Rezoning Transportation Analysis

Petition Number: #2021-120

Date	Description
09-28-2022	First Review (AO)
10-27-22	Second Review (TM)
11-28-22	Third Review (TM)

Revised Site Plan 11.14.22

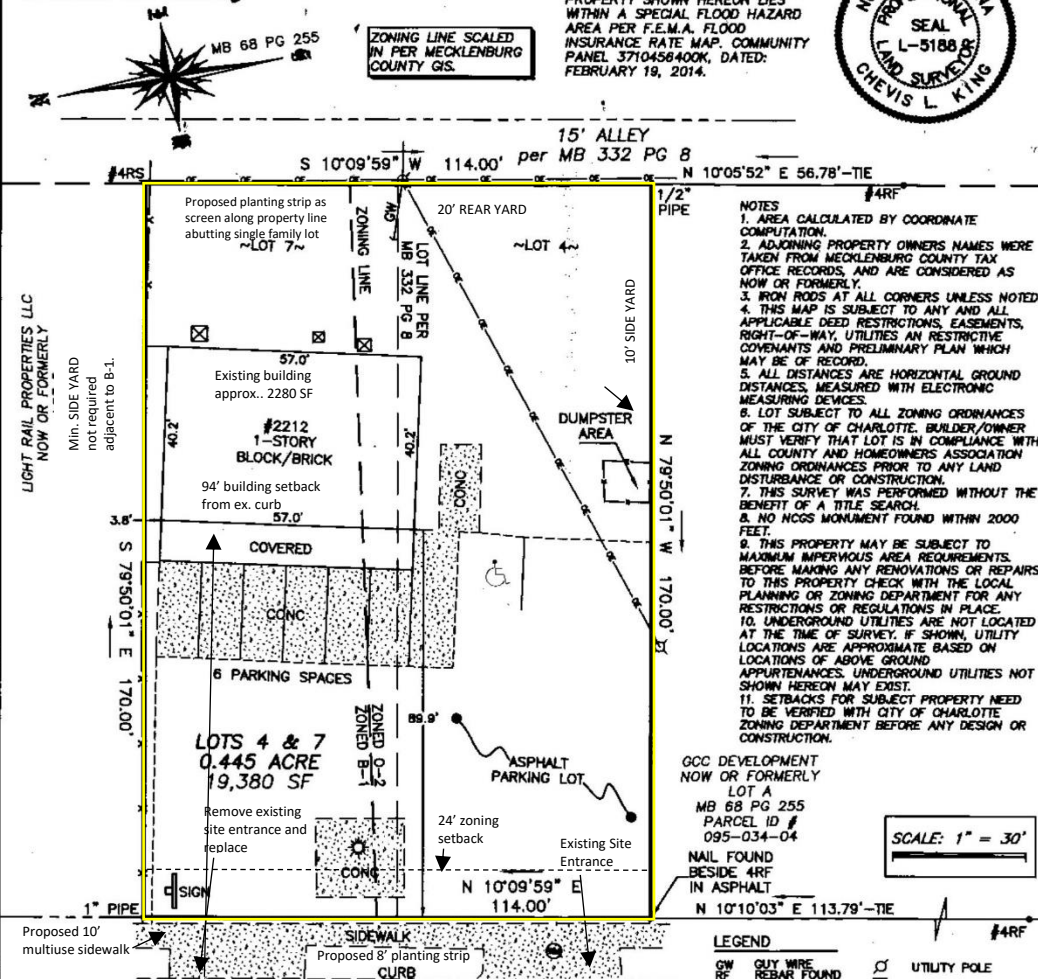
3. Revise site plan and conditional note(s) to commit to dedicate minimum 50 feet of right-of-way from the road centerline of The Plaza if it does not currently exist. The site plan shall label and dimension the right-of-way from the road centerline.

Outstanding Comment 10-27-22: Dimension right-of-way from the centerline of the roadway. Add conditional note committing to dedicating 50-feet of right-of-way if it does not currently exist.

5. **Outstanding Comment from 9-28-22:** Revise site plan and conditional note(s) to commit to removing existing bike ramp and green pavement markings just north of site. The site plan shall label and dimension both items from the back of curb and gutter.

Outstanding Comment 10-26-22: Revise site plan and conditional note(s) to commit to restriping existing green pavement marking to a dedicated right turn lane and removing existing bike ramp just north of the site. The site plan shall label and dimension both items from the back of curb and gutter.

7. ~~Comment from 9-28-22:~~ Revise site plan and conditional note(s) to commit to remarking pavement markings and building a bike ramp near south property line to transition bicyclists from separated bike lanes to multi-use path.

Outstanding Comment 10-26-22: After further coordination the above design has been updated as follows to. Revise site plan and conditional note(s) to commit to remarking current bike lane pavement markings to a dedicated right turn lane, a bike ramp near south property line per CLDSM 10.43 to transition bicyclists from separated bike lanes to multi-use path and extending the 10-foot multi-use path to the southern property.

8. **New Comment from 11-28-22:** Revise conditional note saying "Removal of second driveway if needed according to CDOT ordinance for NS Zoning" to say "Close northern driveway". Revise callout saying "Remove existing site entrance and replace" to say "Close northern driveway".
